STATE OF NORTH CAROLINA  
DEPARTMENT OF TRANSPORTATION

September 21, 2015

Subject: **Modification Request for Section 404 Nationwide Permit 23, Section 10 Permit, CAMA Major Development Permit, and Section 401 Water Quality Certification** for proposed widening of the US 17-74-76/NC 133 from the NC 133/SR 1472 Interchange to the US 421/NC 133 Interchange, Brunswick County. Federal Aid Project No. NHS-0017(68); TIP No. R-3601.

The purpose of this letter is to revise our most recent submittal for Site 10 and request modifications and a letter of refinement of the issued permits to further accommodate construction of the temporary work bridge on the south side of Structure 107. Please find enclosed the revised permit drawing sheets 28, 29, and 44 for the above referenced project.

**PERMIT DRAWING**  
**SHEET 29 OF 44**

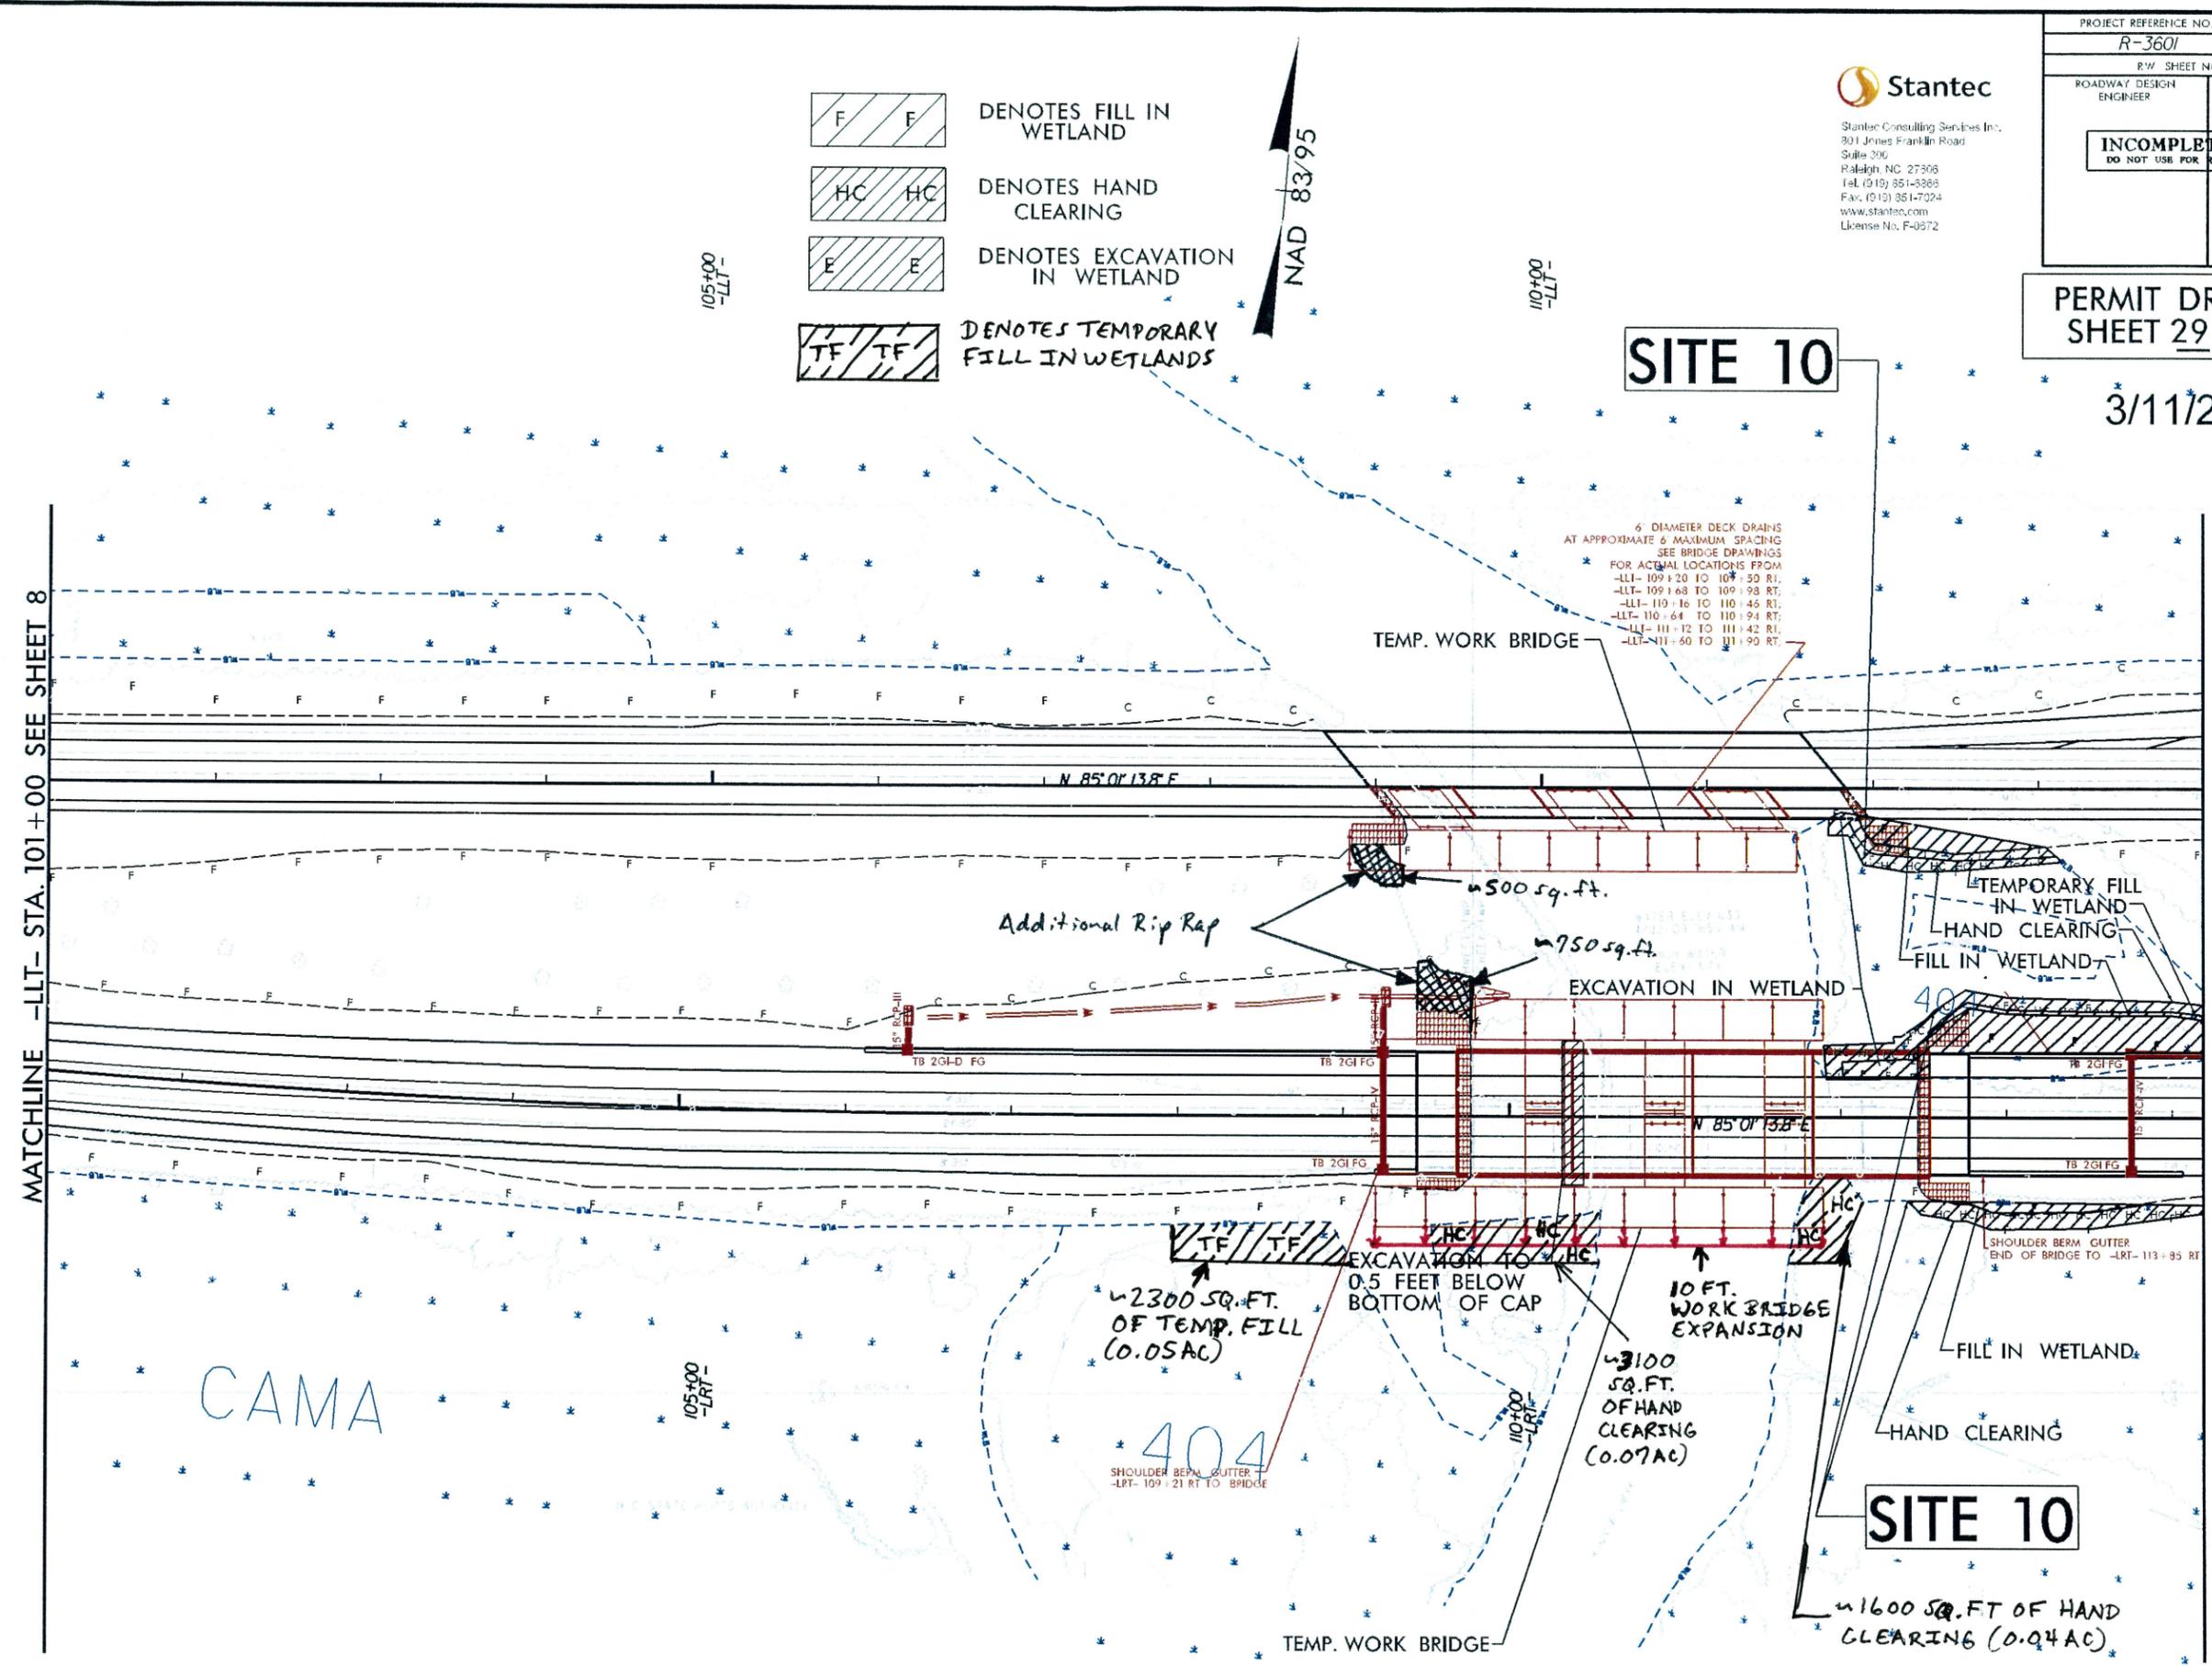
The contractor needs an expansion of the work bridge by ten feet additional to the south side of the original proposed work bridge. This necessitates additional temporary fill needs for the approach to the proposed widened work bridge which also creates additional hand clearing needs. Our last request did not account for hand clearing at the east end of the proposed work bridge, however, we feel that it is needed in this location.

Totals are as follows for this revision: 1) 10 feet expansion of the work bridge to the south side. (2) 0.05 acre of temporary fill for the work bridge approach. (3) 0.11 acre of hand clearing for the work bridge.
